**RTS - SECTION 4.55(1A) MODIFICATION TO BAYS 5-15 OF LOCOMOTIVE WORKSHOP
MOD 9 – SSD 8449 - 2 LOCOMOTIVE STREET , EVELEIGH NSW 2015**

OUR REF: R/2017/11/N

I refer to your request dated 21 July 2020 for City of Sydney comments in relation to the Response to Submissions in regards to Mod 9 of SSD 8449 (Bays 5-15) at the Locomotive Workshop, South Eveleigh.

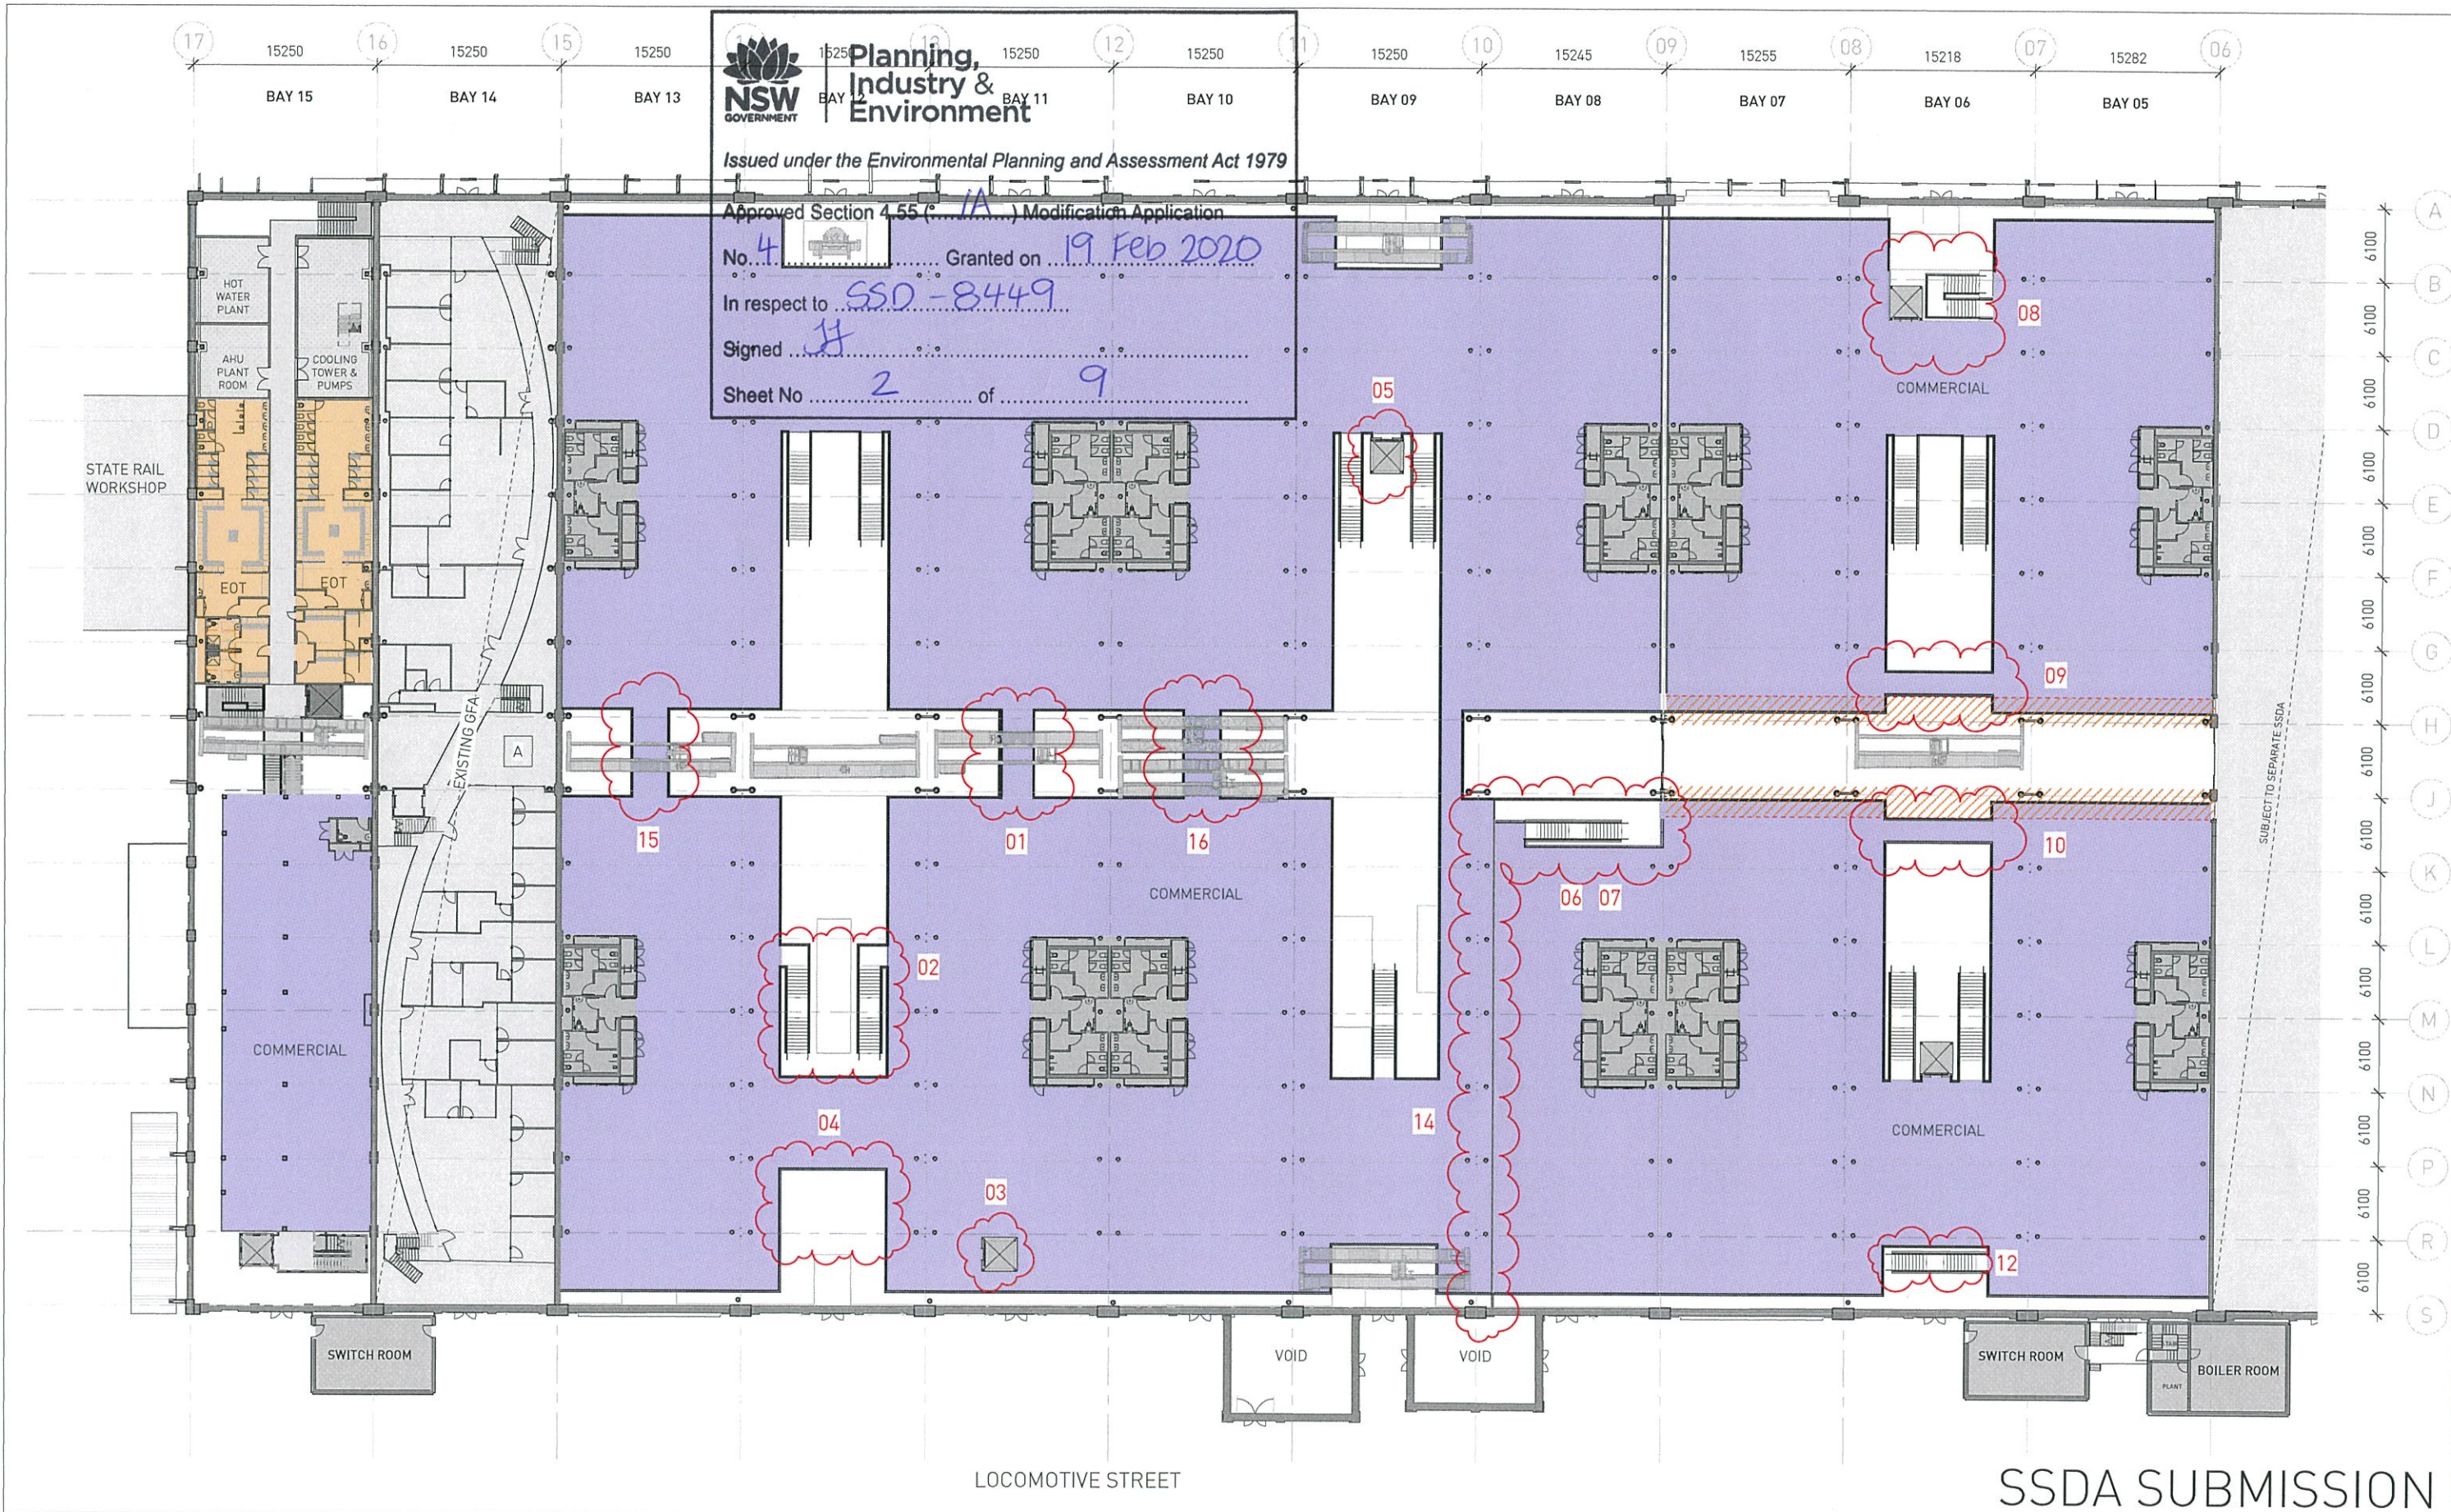
We previously noted that one central bridge rather than 2 bridges would be preferable from a heritage perspective, to reduce visual clutter along the central spine.

The deletion of the bridge to Bay 5 as shown in plan SA-AR-DWG-BB-B4-0231 Rev EE is supported.
